**S.4.55(1A) MODIFICATION 3, SSD-66777221 – LANCELEY PLACE DATA CENTRE,
MINOR ARCHITECTURAL PLAN MODIFICATION**

This is the **third (3rd)** modification to SSD-66777221 and **seeks minor architectural updates to the switch room and reinstatement of a Lanceley Place crossover.**

3 BLOCK AND STACK FROM NORTH WEST

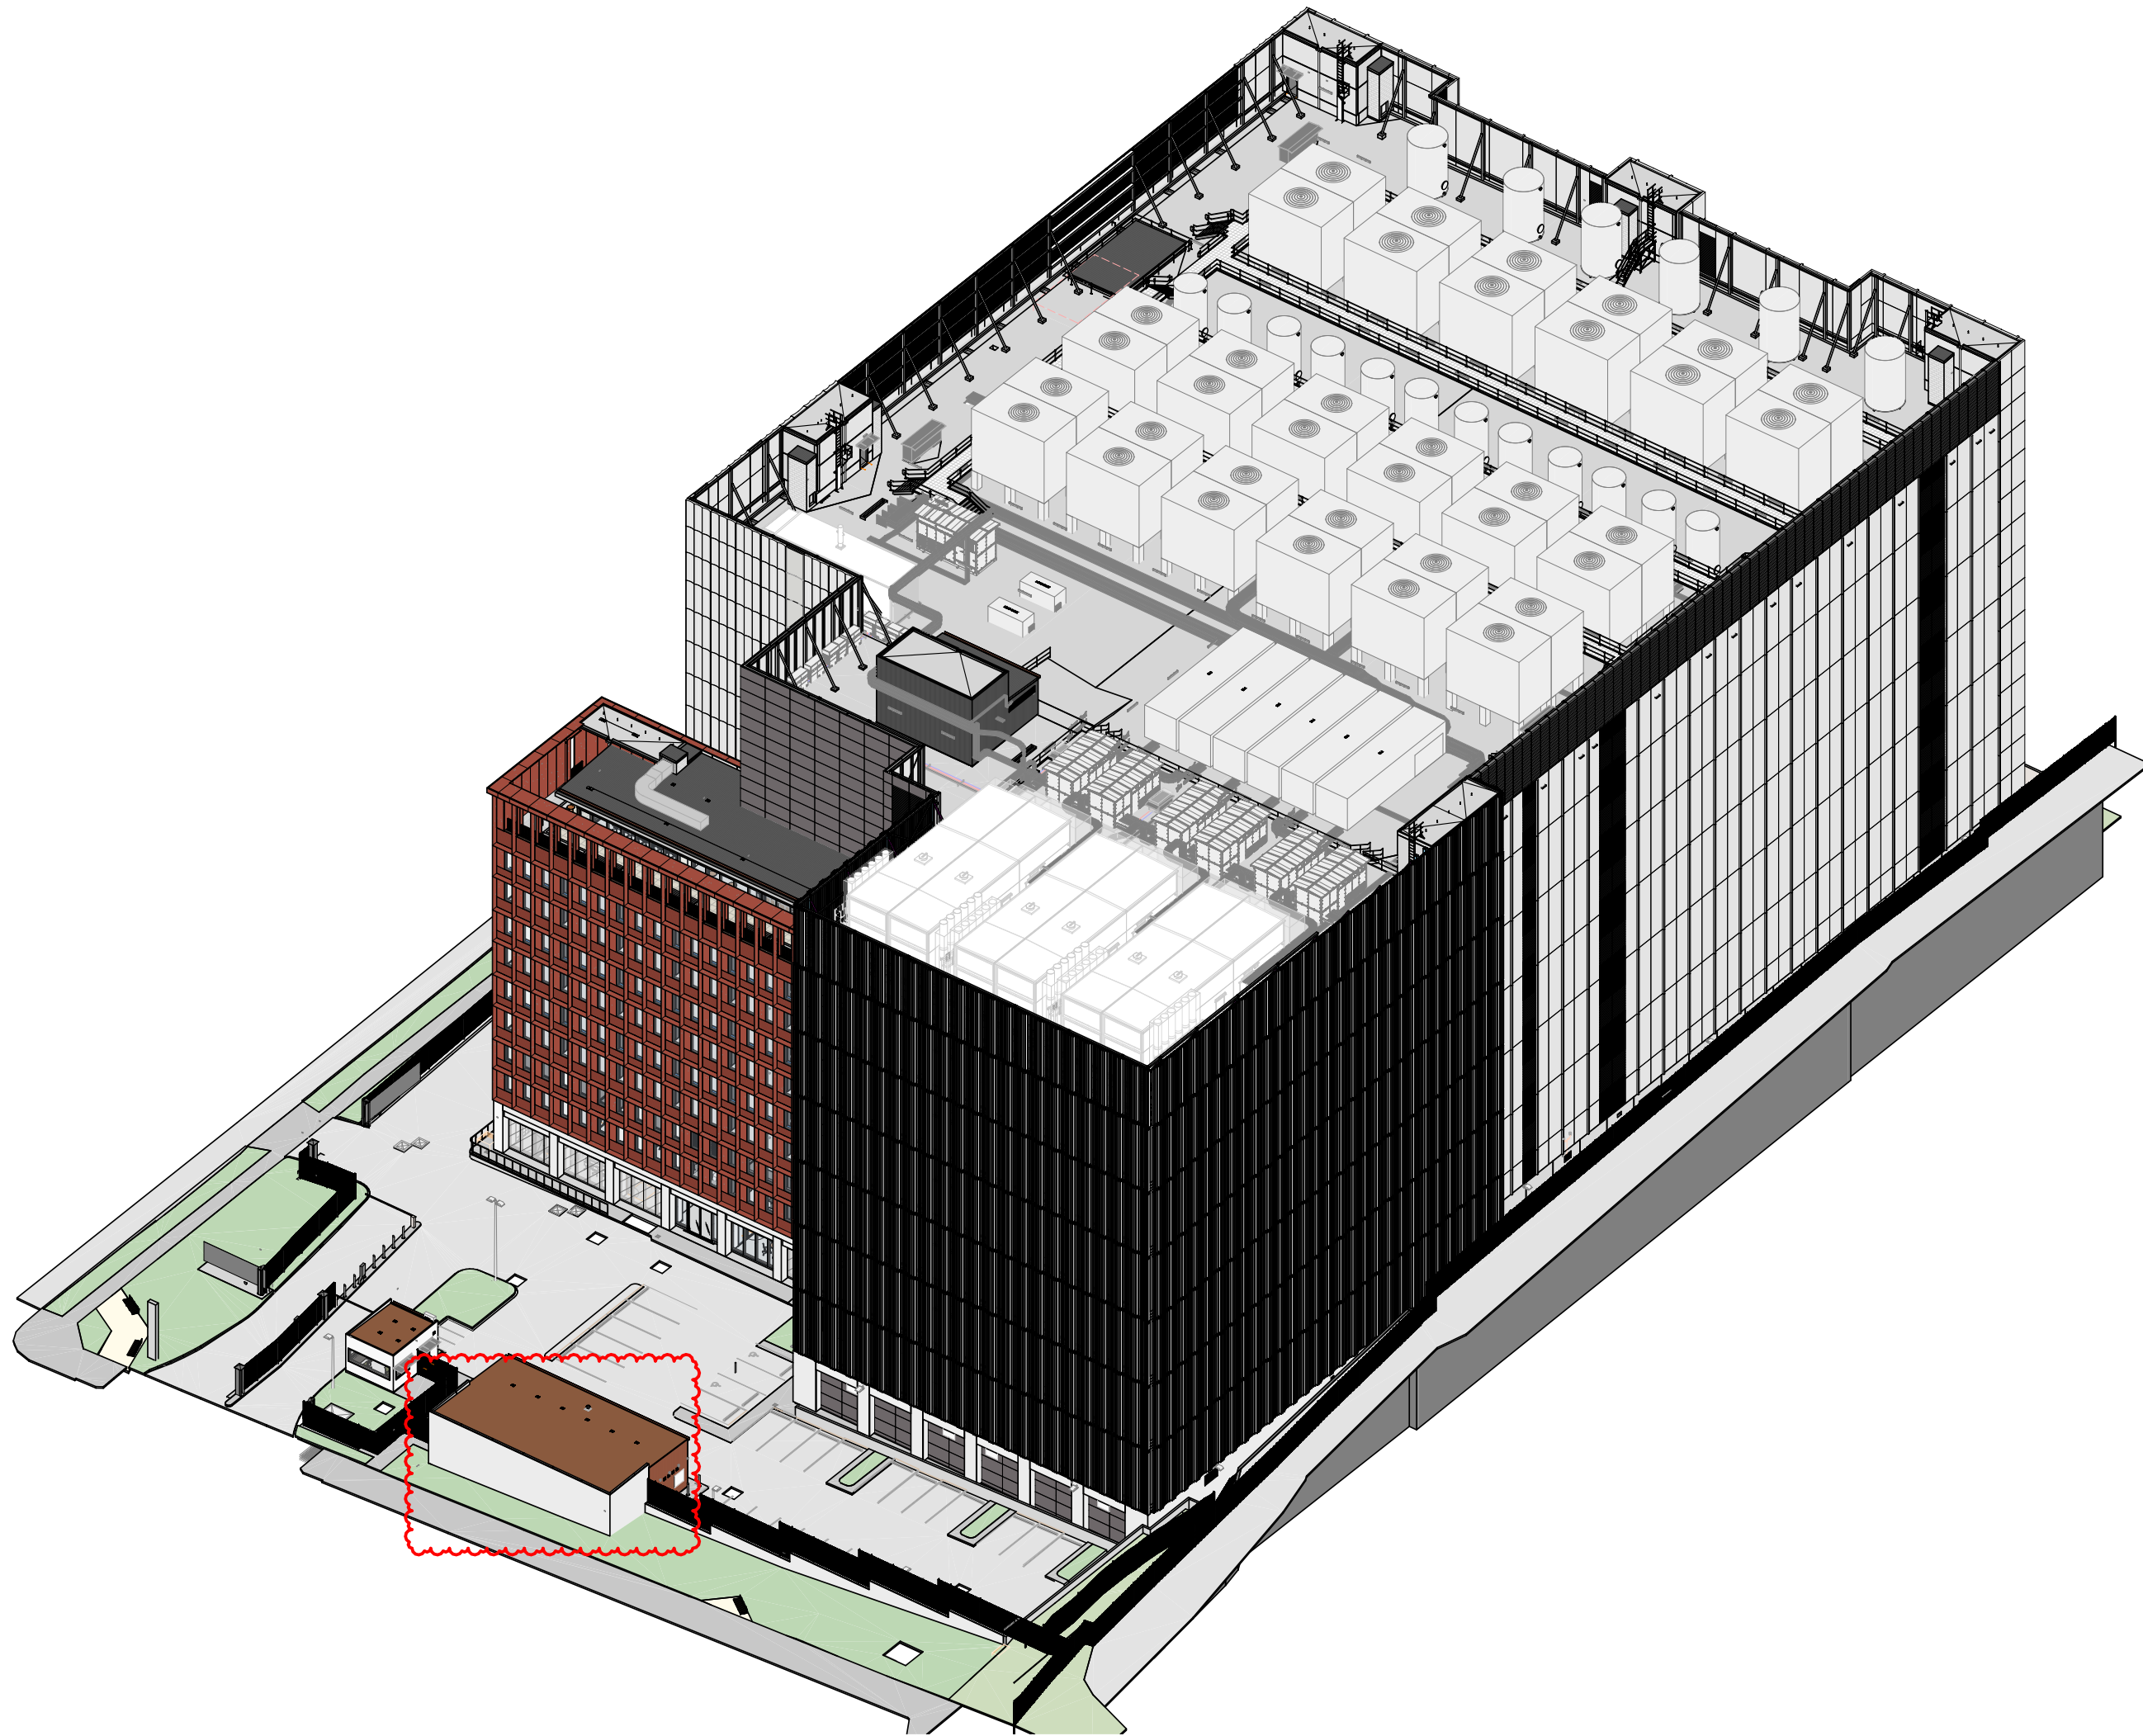
Increase the height of the external switch room located along the site's southern frontage to Campbell Street from 4.045m to 5.250m, an minor increase of 1.205m.

The approved switch room height was based on generic, vendor-neutral air insulated switchgear. GPSA has now selected Eaton gas insulated switchgear (GIS), which is slightly taller than originally assumed. As a result, an extra 1.205m of vertical clearance is needed to allow components to be replaced from the top and rear.
